December 30, 2014

**RE: Revised Grading Plan (C-17D122)
Kirkpatrick Warehouse
Albuquerque, New Mexico**

December 23, 2014

**Re: Kirkpatrick Warehouse
Kirkpatrick Warehouse Drainage Report with Engineer's Stamp dated 11-25-14
Kirkpatrick Grading and Drainage Plan with Engineer's Stamp Dated 12-22-14
(C17D122)**

**RECEIVED**  
DEC 30 2014  
LAND DEVELOPMENT SECTION

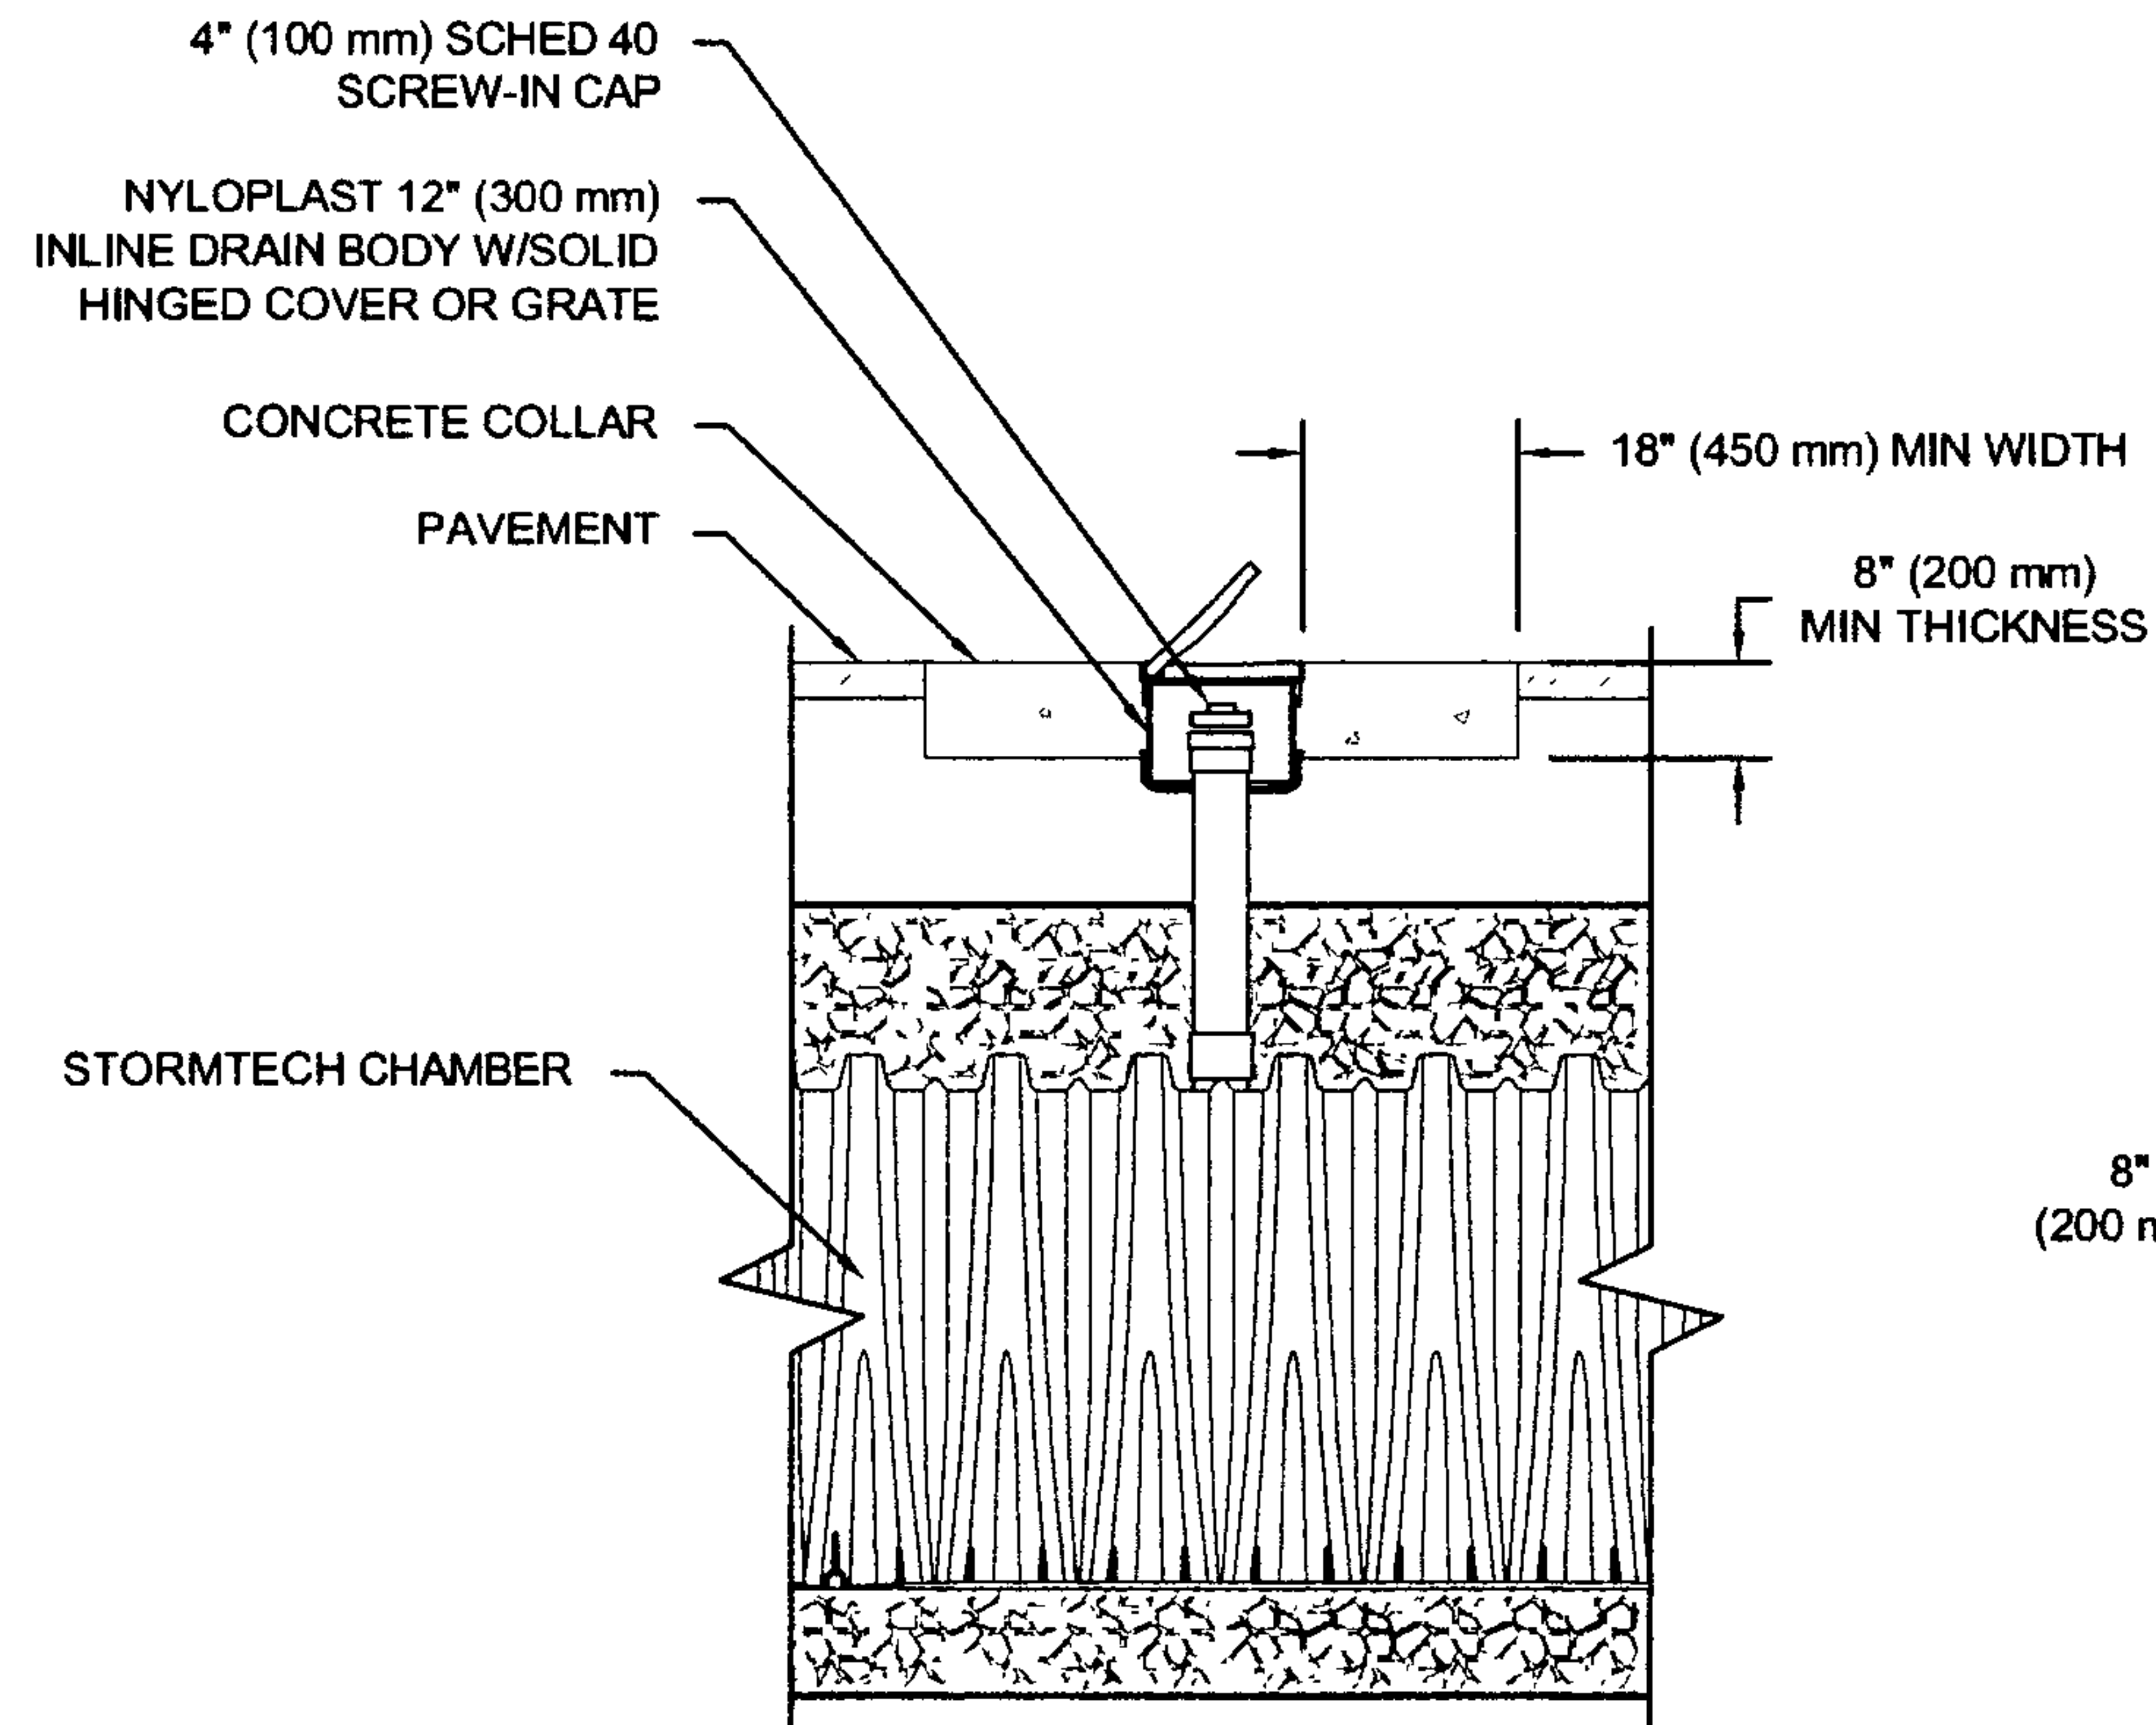
4. Specify manifold, and separation, how is system to be cleaned

1. Include calculations for the design of the Stormtech system.
2. Provide a detail sheet for the Stormtech system that includes plan and profile views.
3. The inlet grate is at 94.25 but the invert is at 59.75. What should the invert really be at?
4. How will the manifold system be set up? How far apart are the rows? How will flows go into the isolator row? How will the isolator row be maintained and cleared of debris?
5. You have specified S780. Do you mean DC-780? What stub are you specifying?
6. What are the depths and type of stone for the whole system?
7. What kind of geotextile is being used? Where is the fabric located?

We have better shown how the manifold works, the inlet is an inline basin each leg of the inlet drains to a reach of the system. The details show the separation of 6". We have added inspection ports which are used for maintenance. A vactor truck is used for periodic maintenance.

## ACCEPTABLE FILL MATERIALS: STORMTECH DC-780 CHAMBER SYSTEMS

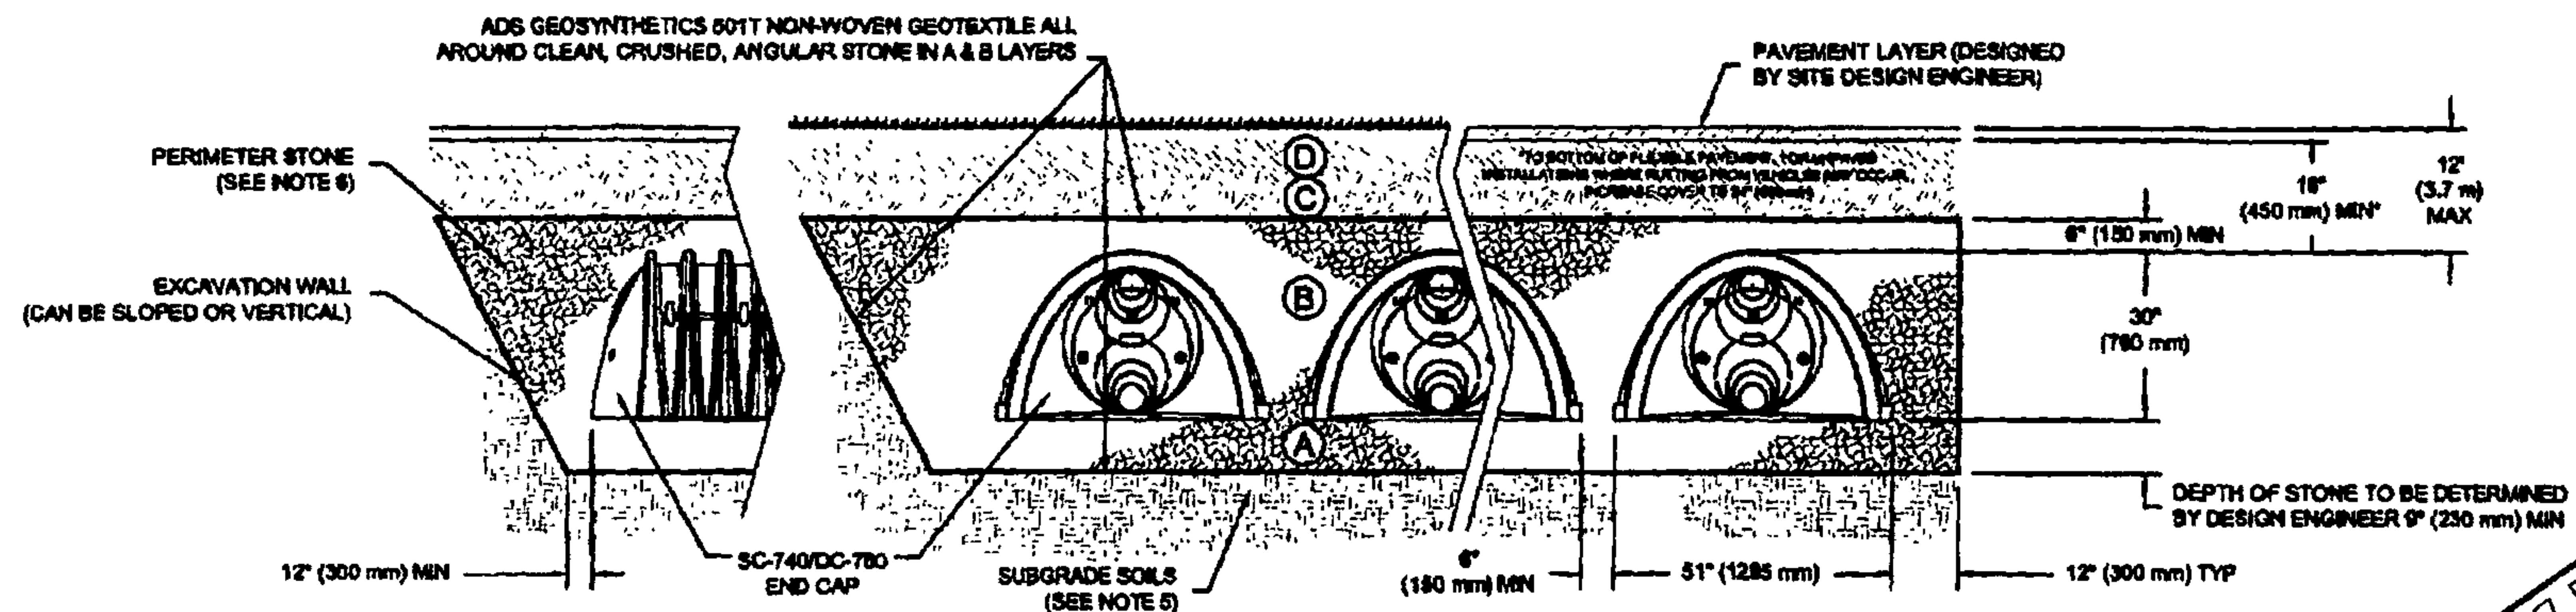
6. What are the depths and type of stone for system

7. what kind of geo textile is used and where is it located

The standard detail shows 9" below, 6" above and 12" on side. The type of stone is on the detail sheet.

The location and type of geotextile is shown on the detail sheet.
